POWERHOUSE ULTIMO RENEWAL

State Significant Development Application

Application No SSD-32927319

NEW SOUTH WALES CHAPTER

Figure 2 3D view of the proposed maximum building envelope

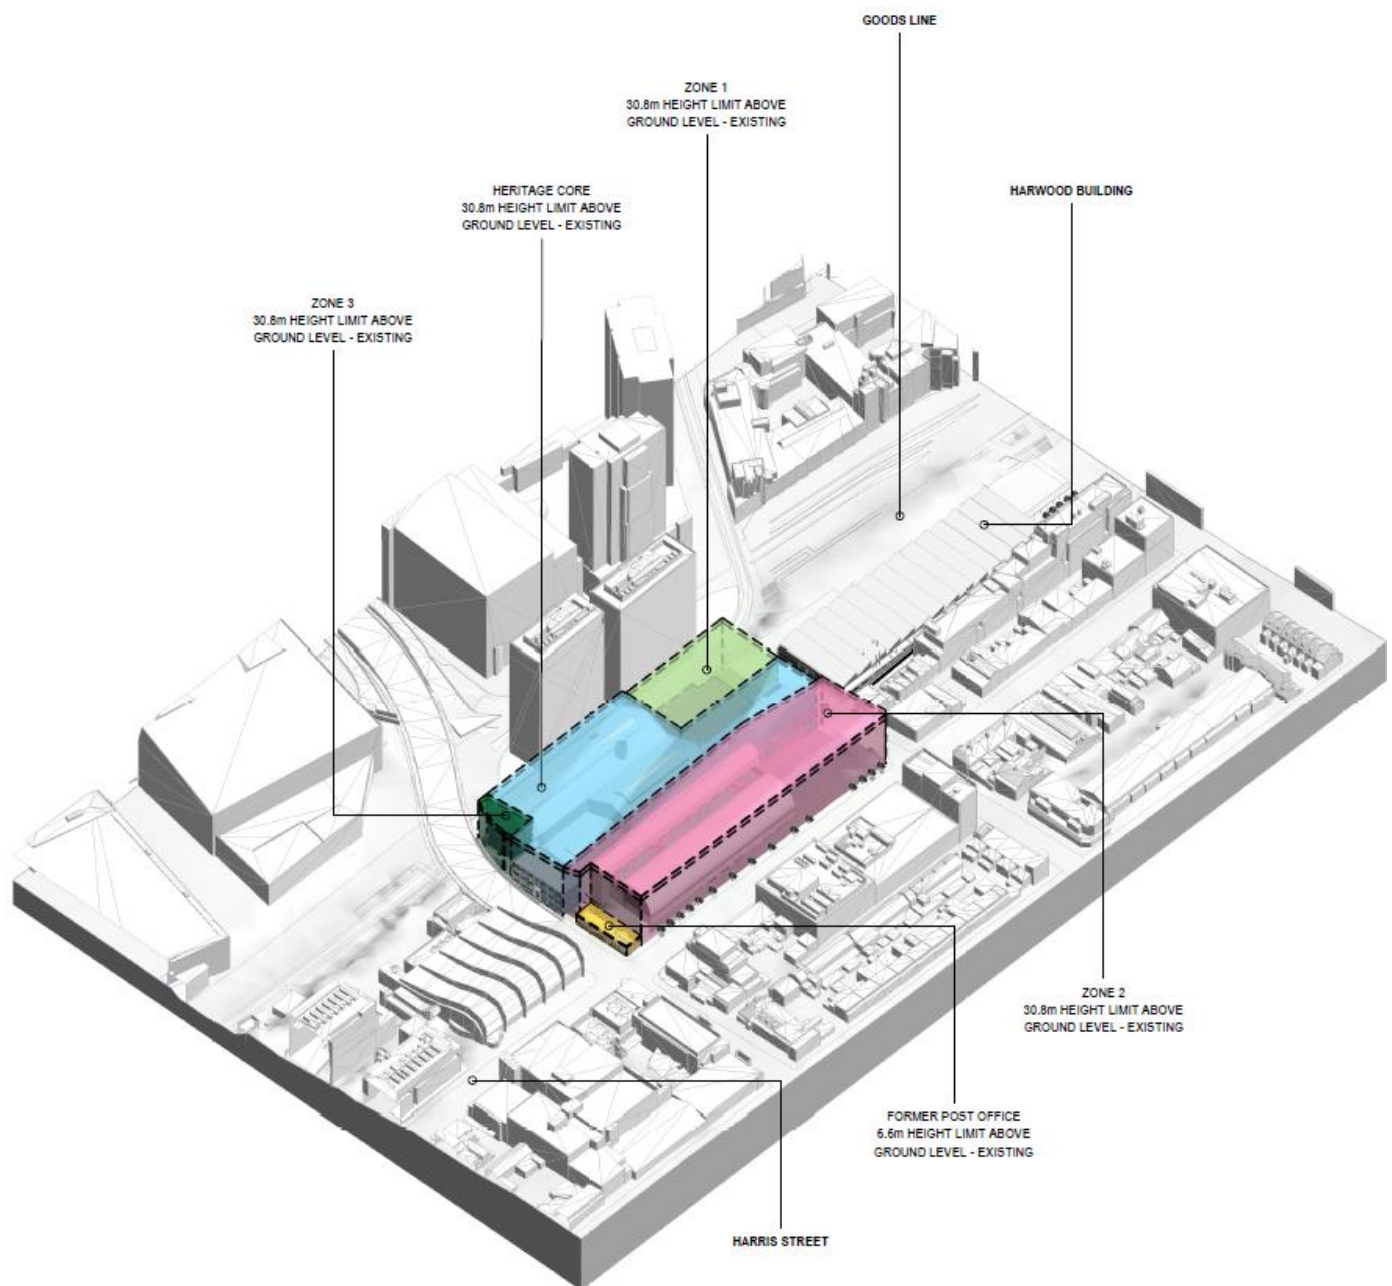
By proposing a 'loose fit envelope' which is visually represented in this application as a 'box' over the site it is unclear how an adequate assessment of built form and urban design can be made. The reference design does not appear to address or engage with the existing building fabric on the site, and an understanding of the significance of the Wran building, Galleria and overall 1988 adaptive reuse of the Powerhouse precinct is not demonstrated.

The Institute believes a masterplan is necessary to clearly assess impacts on public space, given this application seeks wide development approval for a large, bulky building envelope. The application seeks the approval of large buildings on both existing public spaces. This seems to be contrary to more than one of the design principles in the EIS section on urban design, including p.33 in the EIS *'to maintain or increase the quality or quantity of the public domain on the site, and reveal and celebrate heritage fabric and spaces to the wider public domain'*. Without the guidance of a masterplan it is difficult to visualise how these objectives can be sustained.

Similarly, the Institute maintains, the absence of any clear proposed form or building detail makes assessing the visual impact unclear. Based on the images provided by the proponent, we believe the proposed building envelope substantially diminishes any view of the significant buildings which currently inhabit the site from every direction. In addition, the proposed building envelope suggests a deleterious addition to the Harris Street streetscape and urban form. See Figure 1.
